**KIRKLEES COUNCIL
TOWN AND COUNTRY PLANNING ACT 1990
HIGHWAYS DEVELOPMENT MANAGEMENT**

PLANNING REF 2018/62/91661/E0/GW
CATEGORY Small Major

PROPOSAL OUTLINE PERMISSION FOR RESIDENTIAL DEVELOPMENT AND FACILITATING ENGINEERING OPERATIONS AND FULL PLANNING PERMISSION FOR ACCESS AND SPINE ROAD

LOCATION LAND AT WALKLEY TERRACE AND BRUNSWICK STREET, HECKMONDWIKE

Drawing Title: Proposed Site Plan

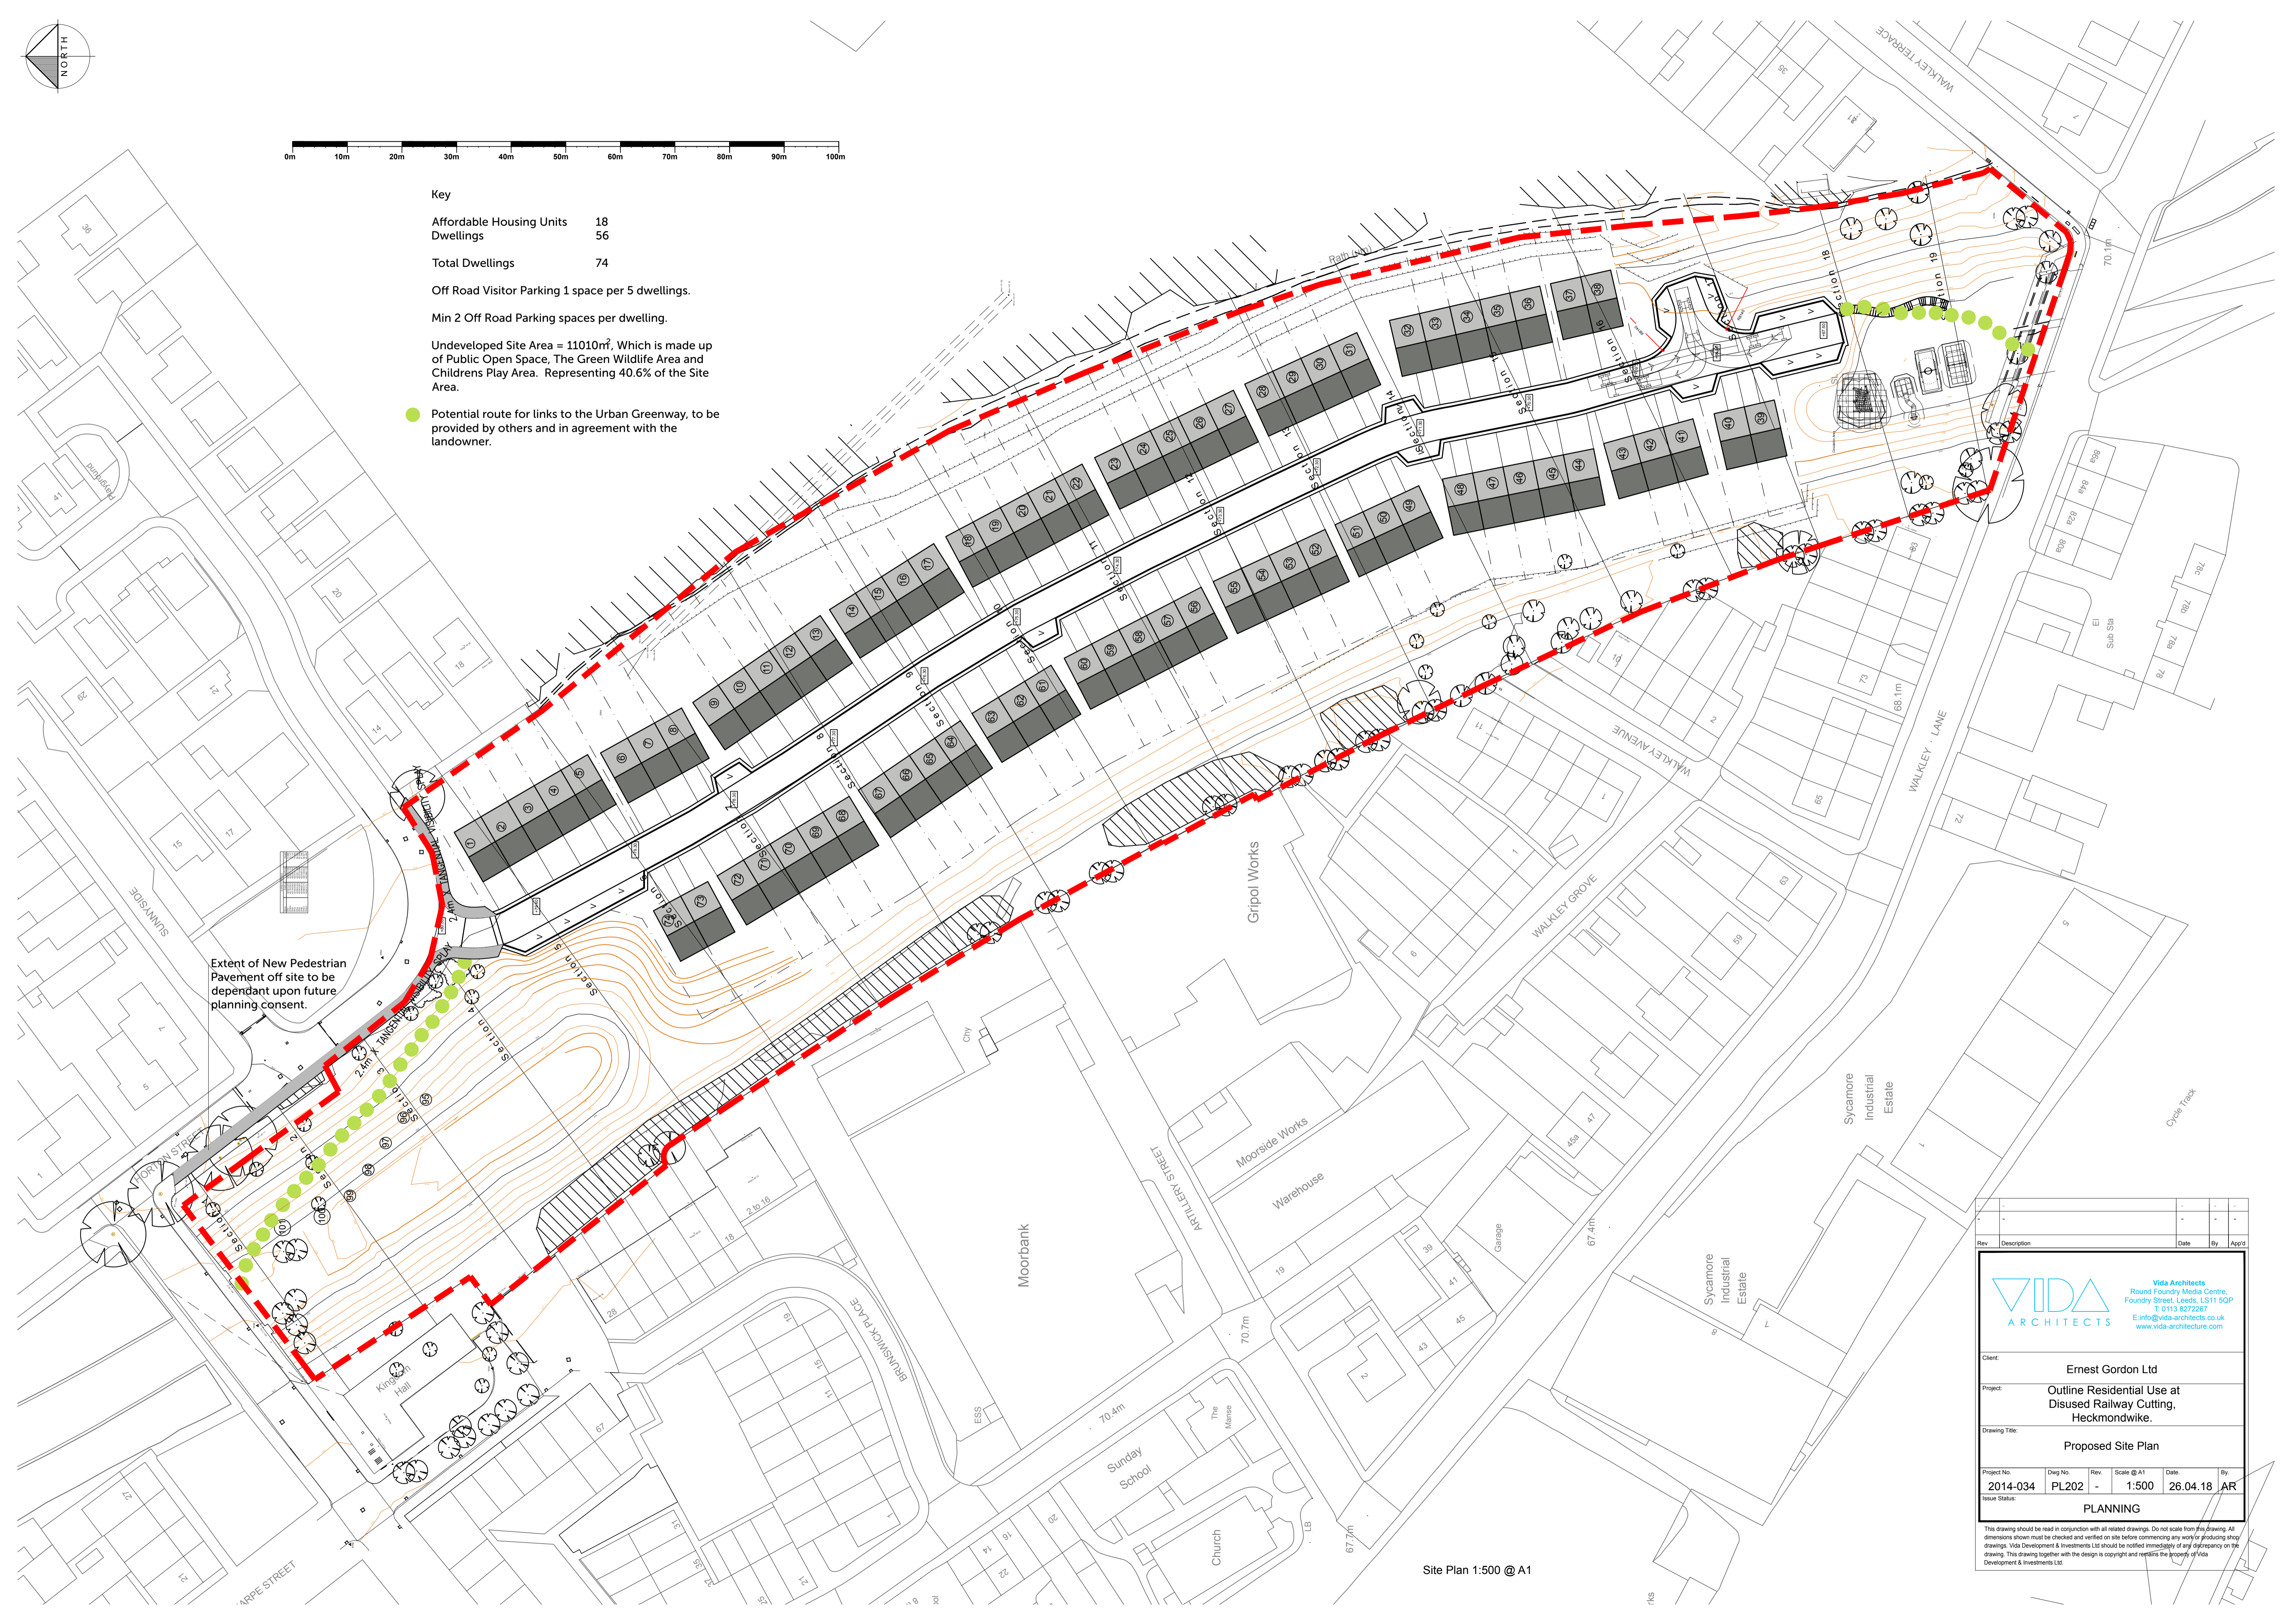
This identified the need for pedestrian crossing points to be shown across the junction with Horton Street and vehicle restraint to the top of the existing embankments at the back of the proposed footways.

2, Swept paths to demonstrate that an 11.85m refuse vehicle can enter and exit the site from Horton Street

6, A footway between the site access and Brunswick Street.

Given that an independent road safety audit is provided for the junction with Horton Street and that the proposed development traffic generation is not anticipated to increase queuing significantly at the 3 junctions identified as potentially worst affected by the proposed development these proposals are now considered acceptable to Highways Development Management.
